# CITY OF ALBUQUERQUE

January 23, 2020

**Re: De Anza, Bldg. G**  
**4301 Central Ave NE**  
**30-Day Temporary Certificate of Occupancy**  
**Transportation Development Final Inspection**  
Engineer's/Architect's Stamp dated 12-25-17 (K17D106)  
Certification dated 1-17-20

A1 TRAFFIC CIRCULATION LAYOUT

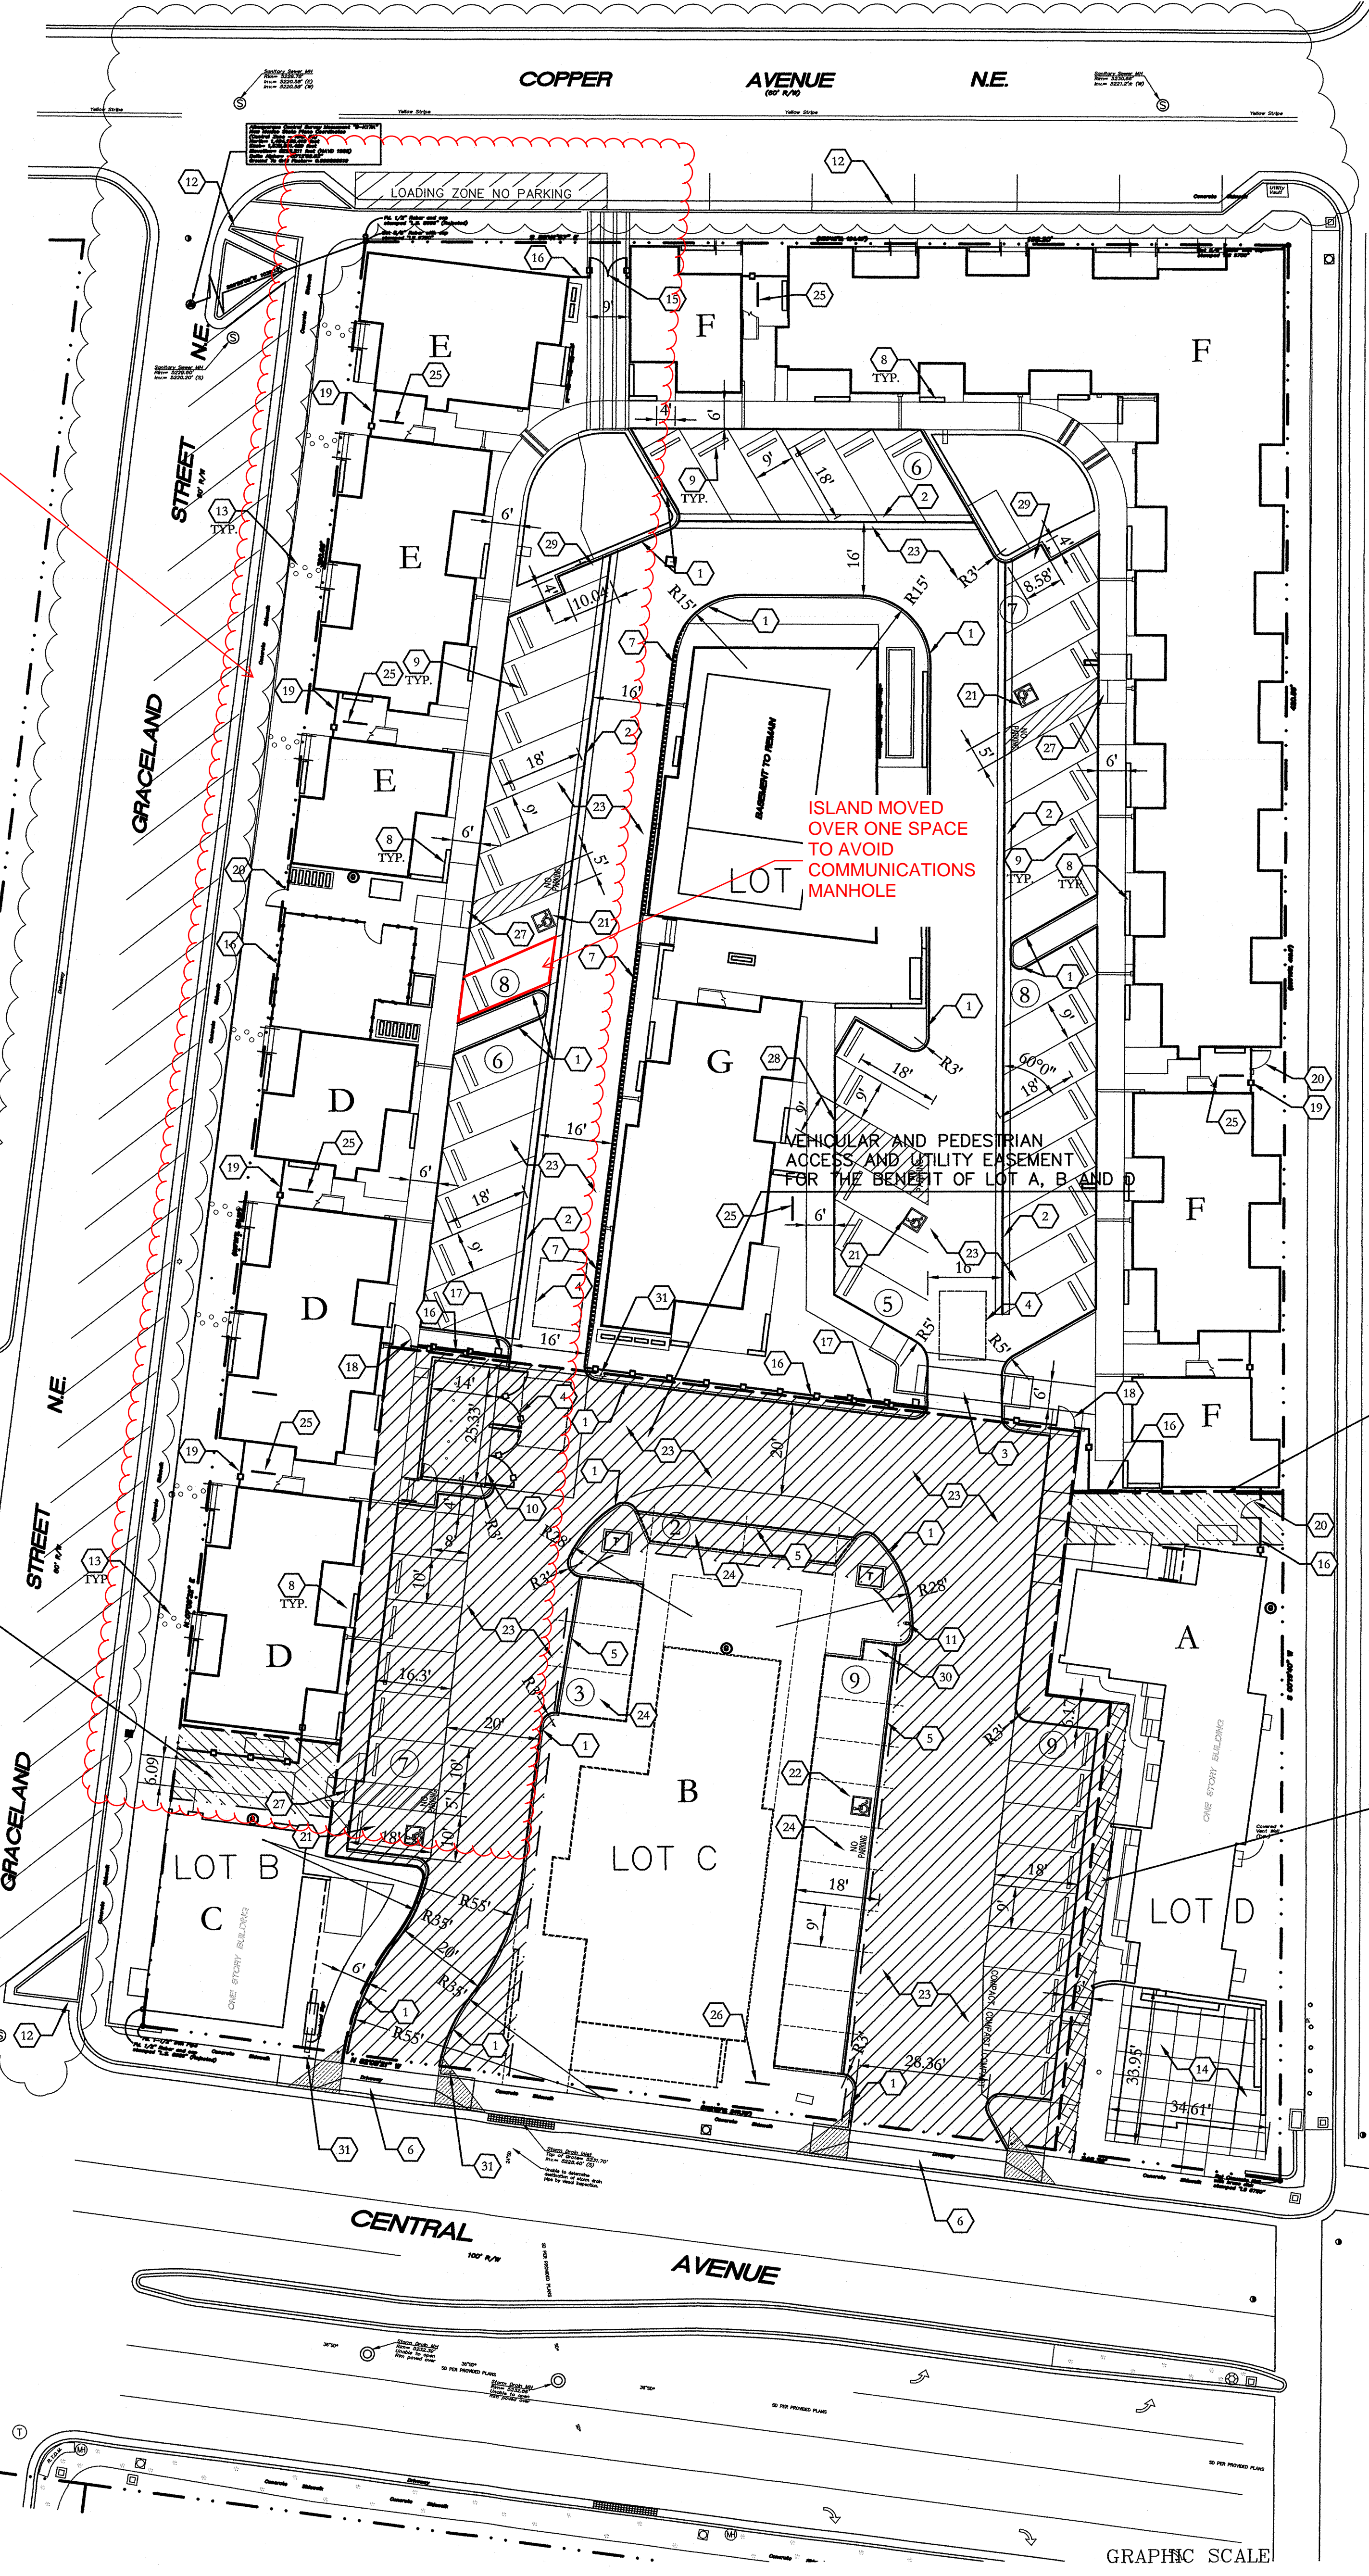
- Van ADA access aisle is missing ramp. Please add ramp or relocate ADA stall and access aisle. (See attached photos)
- Please stamp and date the certification language on the TCL Plan.
